17 December 2020

Objection Letter – Planning Reference: BR/286/20/HH – Removal of existing garage and erection of single storey side and rear extension at 17 Shelley Road, Bognor Regis, PO21 2SL

PROPOSED SINGLE STOREY EXTENSION AT 17, SHELLEY ROAD, ALDWICK
FOR MR. & MRS. K. SIMMONS.

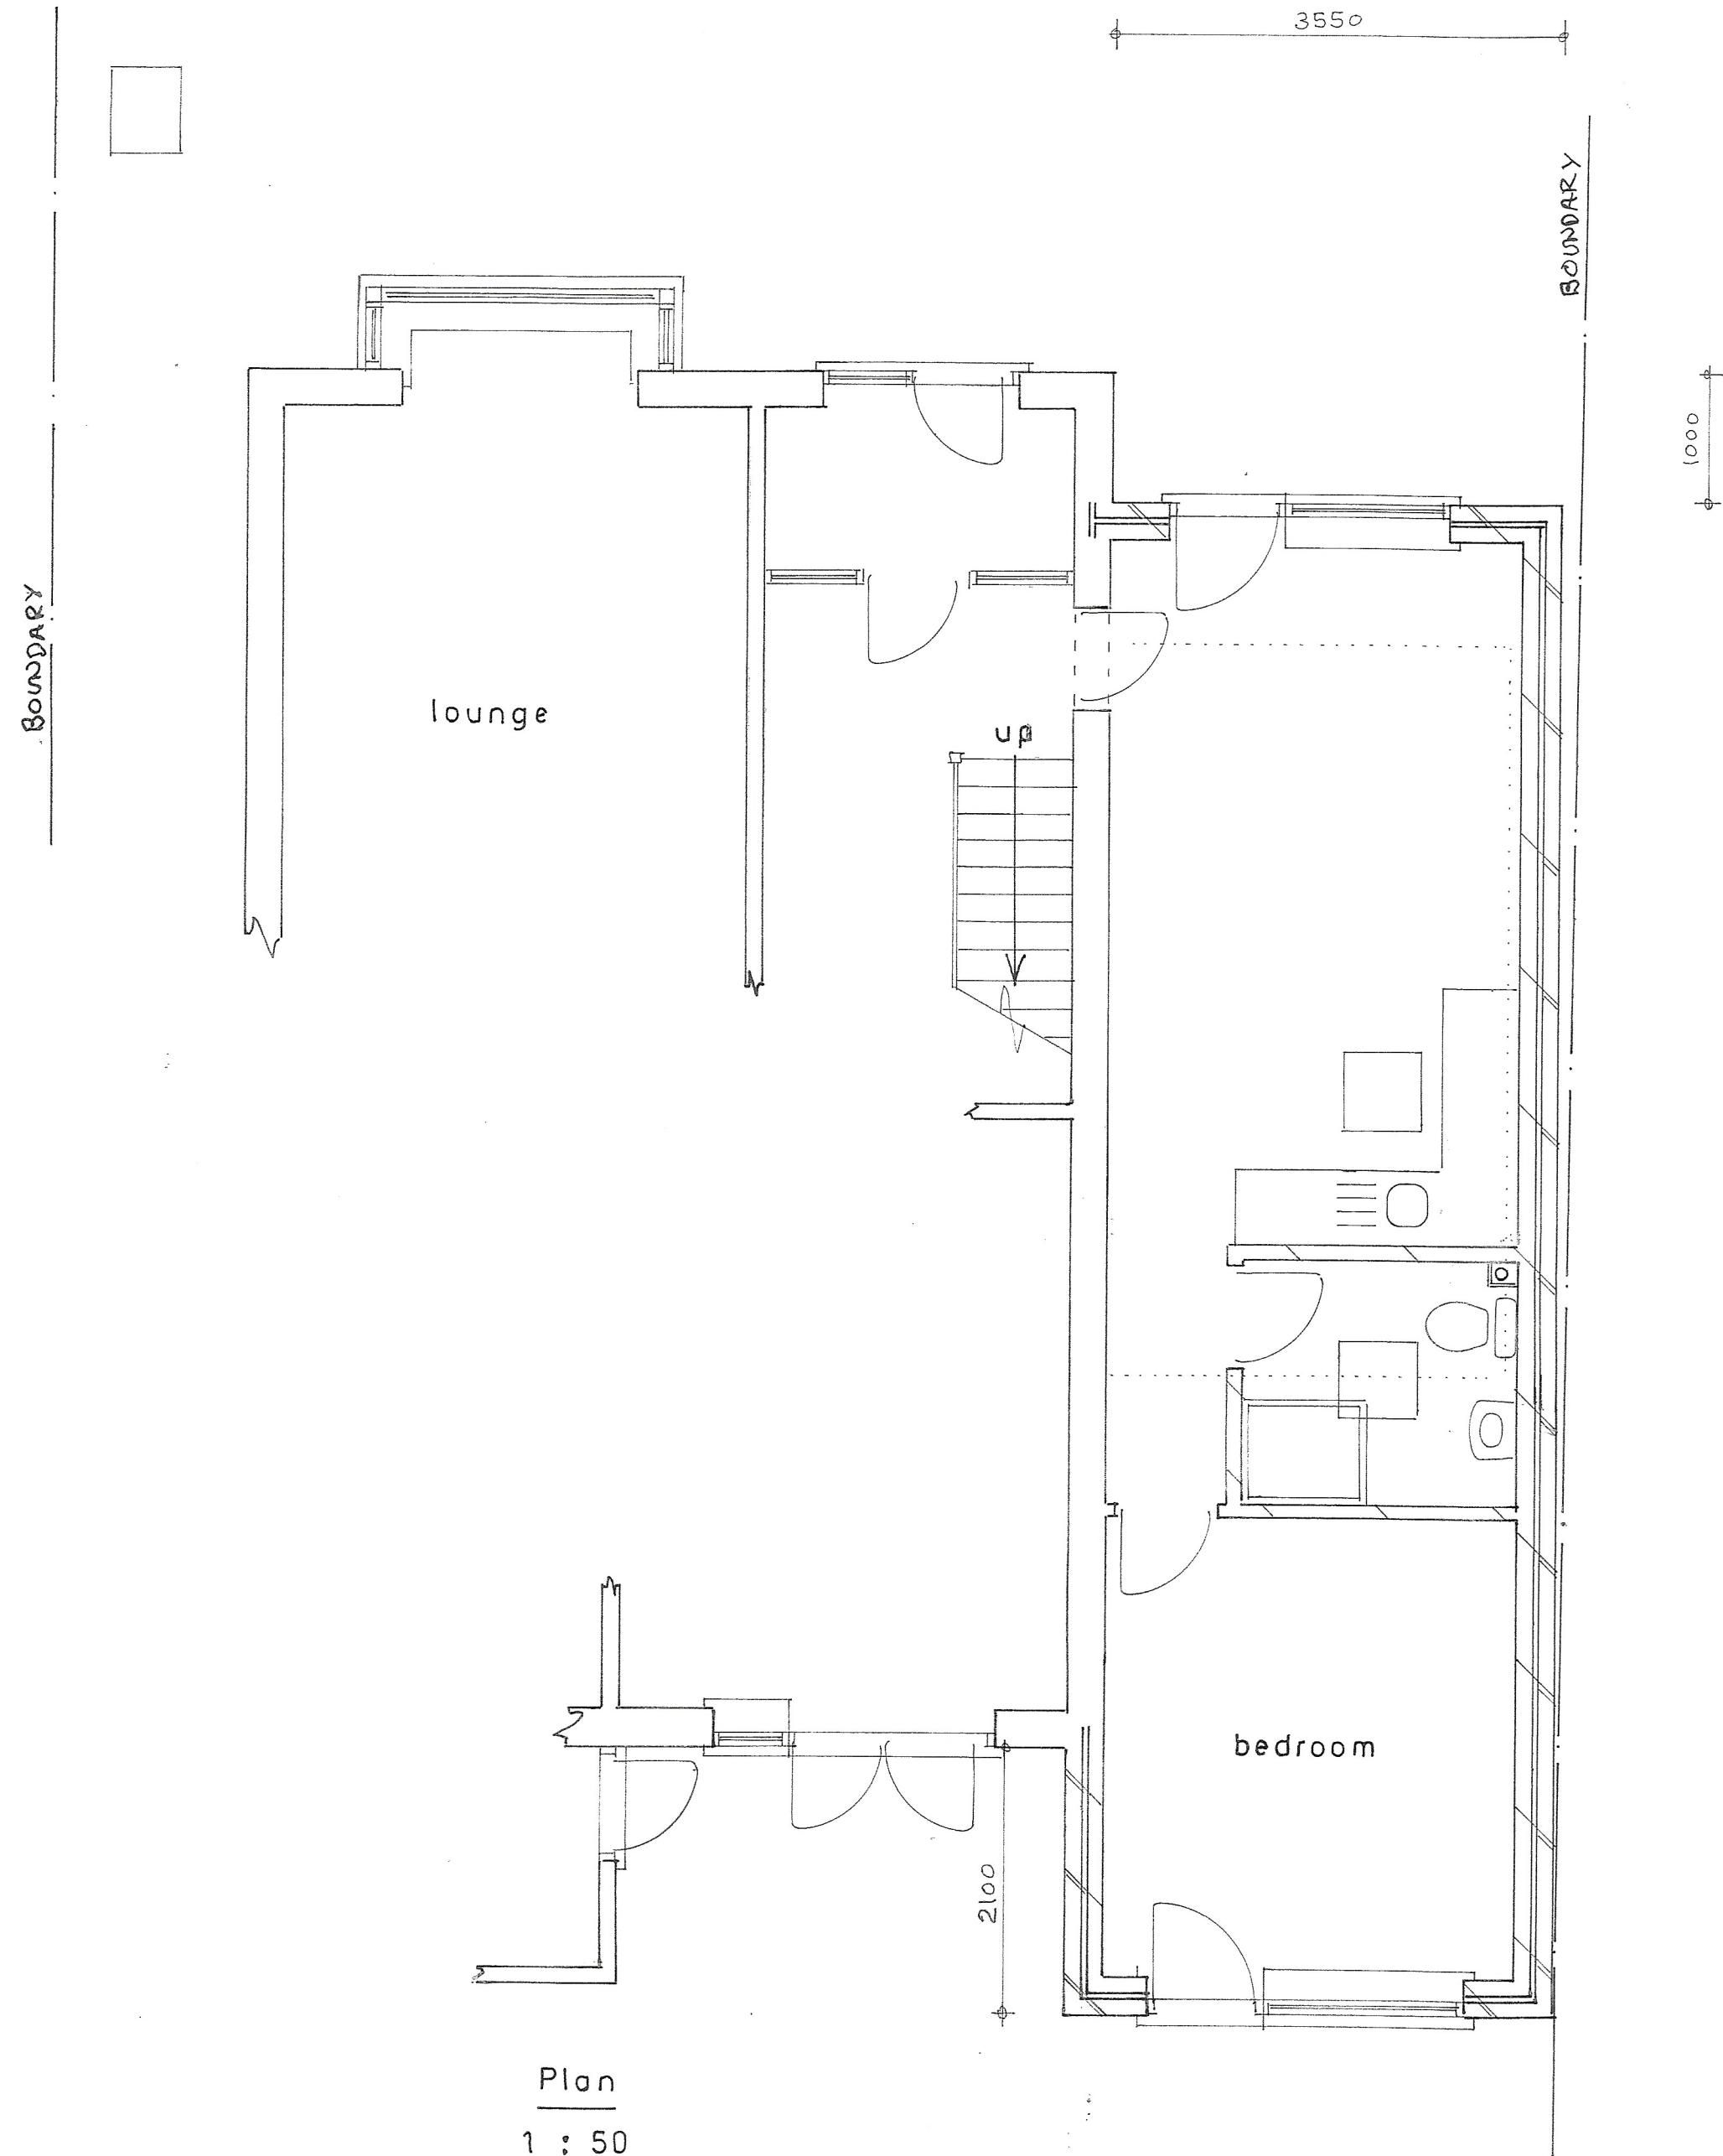
My client's property is located to the east of the application site. The provision of a substantial development adjacent to the boundary with no separation distance is going to lead to a significant loss of outlook and daylight.

Following a review of the plans, it is clear that the proposed development would significantly increase the mass of the dwelling and the amount of built form close to the boundary with

Number 15. The extension will extend a substantial distance off the side and rear of the property adjacent to the boundary and would erode the sense of spaciousness that is currently maintained with the existing garage. As a result, the extension would be extremely prominent from within the property, as well as the rear garden of my client's property.

It is clear that the development will encroach on to my client's property through the provision of an extension on their boundary. It is also not clear how the foundations will be constructed and the guttering appears to be overhanging.

sheet 2 of 3

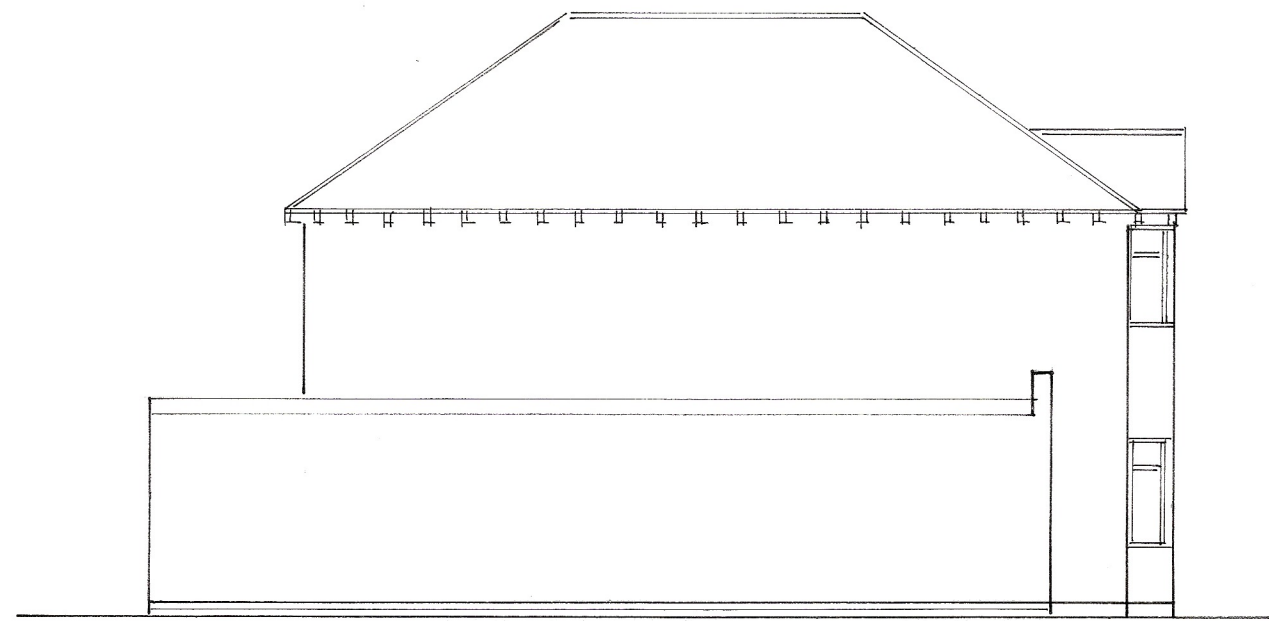
Due to the significant increase in size and mass of the dwelling, it will appear as overbearing structure from not only the window at the rear of my client's property, but from within his private garden area, adjacent to the boundary. The proposal will result in a significant level of overlooking that will have a harmful impact on my client's right to enjoy a reasonable level of privacy within his own home and private garden area.

The proposal fails to respect the simple form and character of the surrounding development. Due to the provision of a substantial development so close to the boundary, it would comprise a dominant and imposing form of development when viewing the site from the rear of my client's dwelling, as well as from the rear of other properties in the area. The level of harm is compounded as the extension does not appear as a subservient addition.

The extended dwelling will appear as completely at odds with the simple form of the immediately adjacent dwellings. The extended dwelling will be of a size, scale and mass spanning laterally across the site. It will be extremely prominent from all neighbouring properties to the detriment of their visual amenity. The resulting dwelling will therefore appear as incongruous, and would have a detrimental impact on the character and appearance of the area.
